Development Control
Ribble Valley Borough Council

Re: Planning Application 20/0507

Address: Land South of Blackburn Road Hothersall PR3 2YY

Description: Outline Planning application for business units use classes B1(b)(c) and B2 and storage use class B8 and associated improvements to existing access with all matters reserved except for access.

Land south of Lower Road, Longridge – Indicative layout

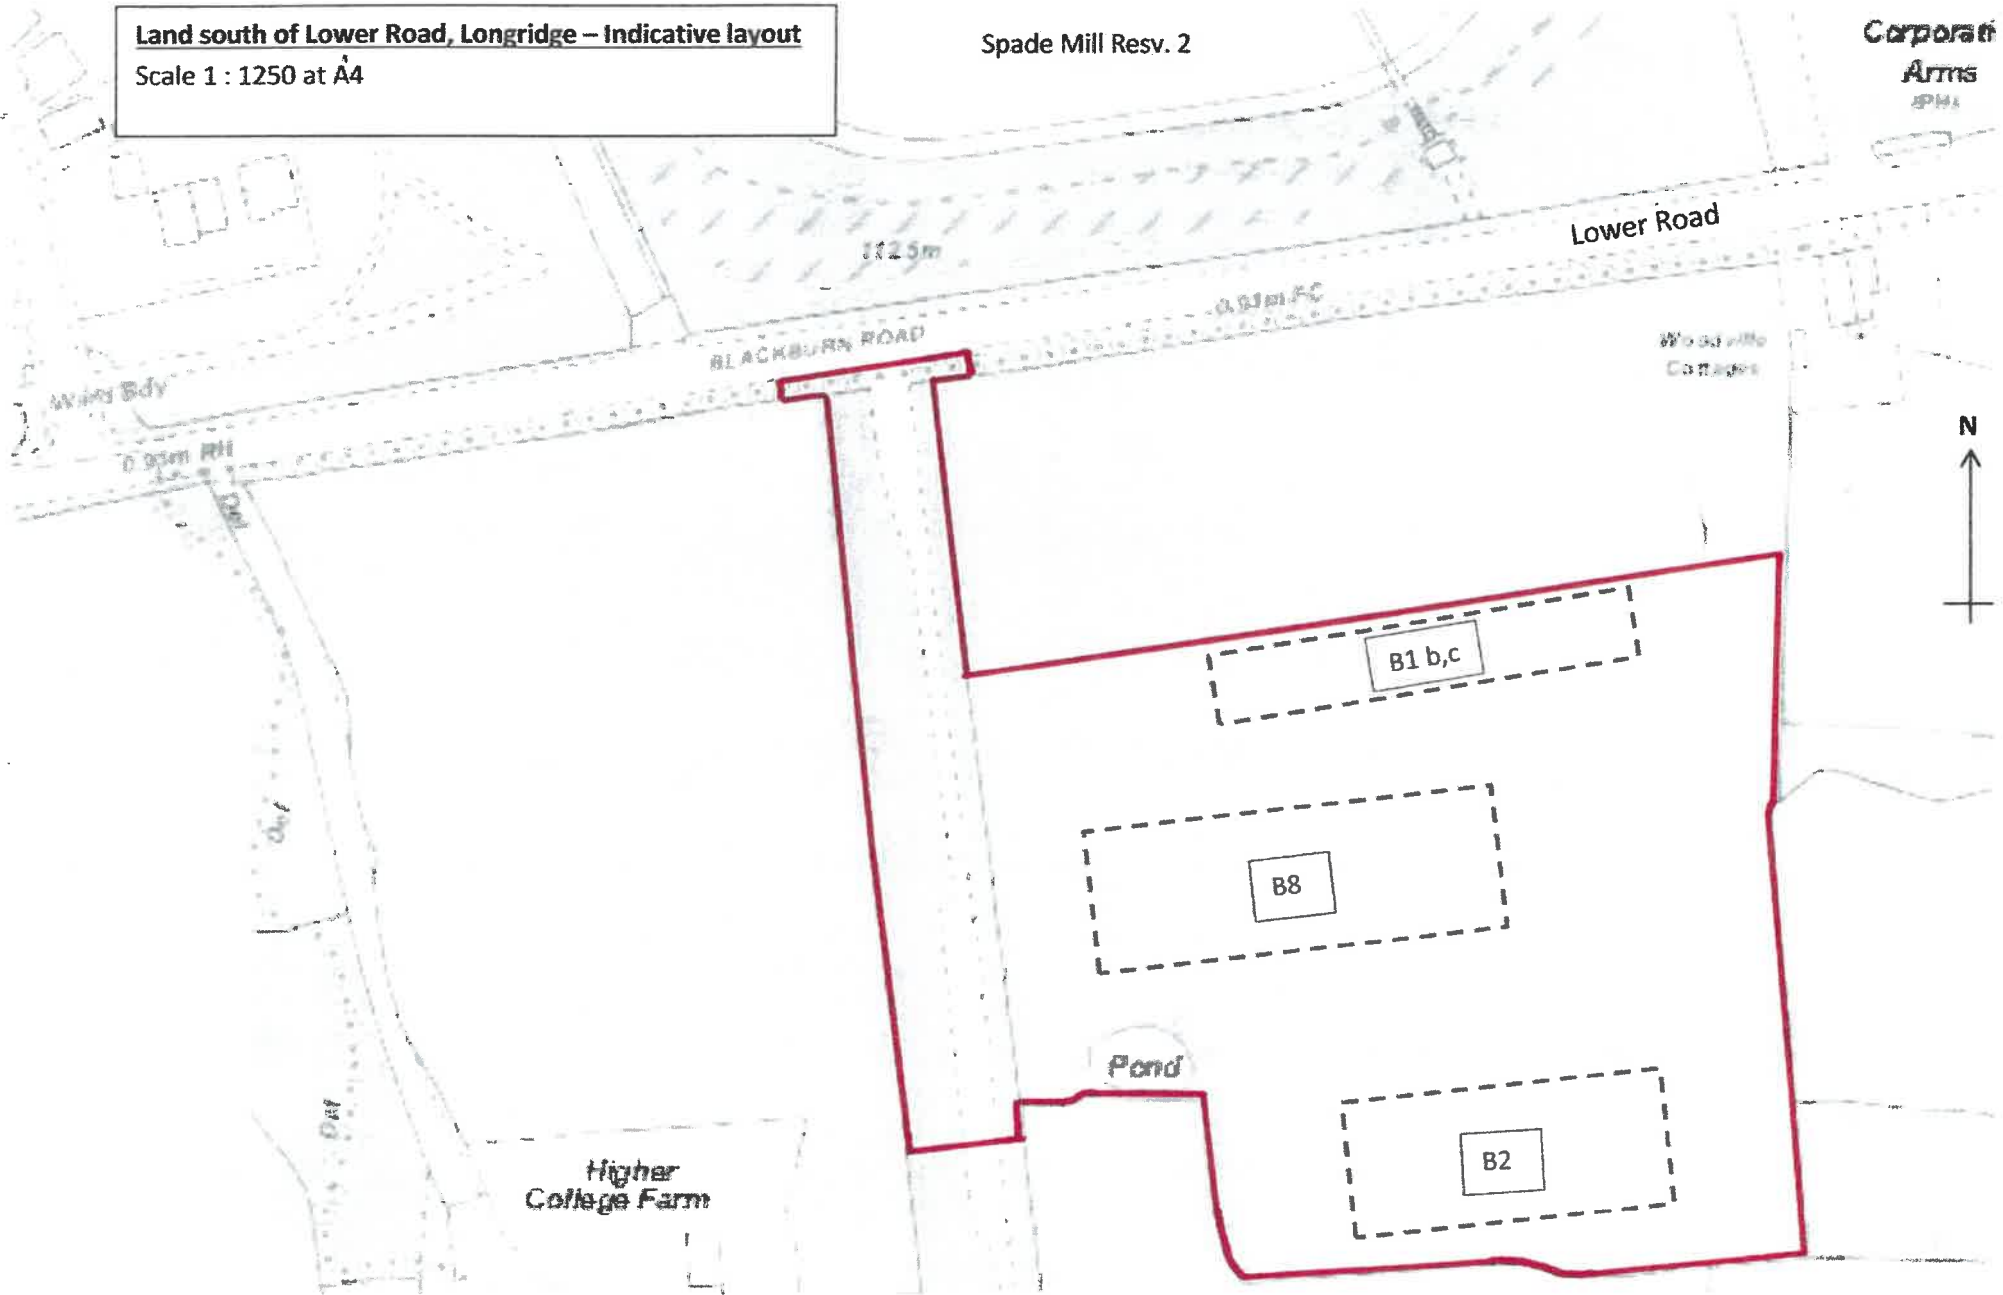
- Each individual premises regardless of their planning class shall be provided with at least one electric vehicle charging point
- A plan showing the parking provision as detailed in the application form shall be provided

- A further plan showing the access to the site from Blackburn Road and the provision of a pedestrian footway
- Due to the increase in the expected traffic flow at the junction of the B6243 and the B6245 a build out to structure a more formal junction should be provided.
- A comprehensive construction management plan including mechanical street sweeping should it be required.
- A section 106 contribution for the improvement of bus stops This may include the re-siting and the provision of a length of footway to ensure safe access to and from the development site.
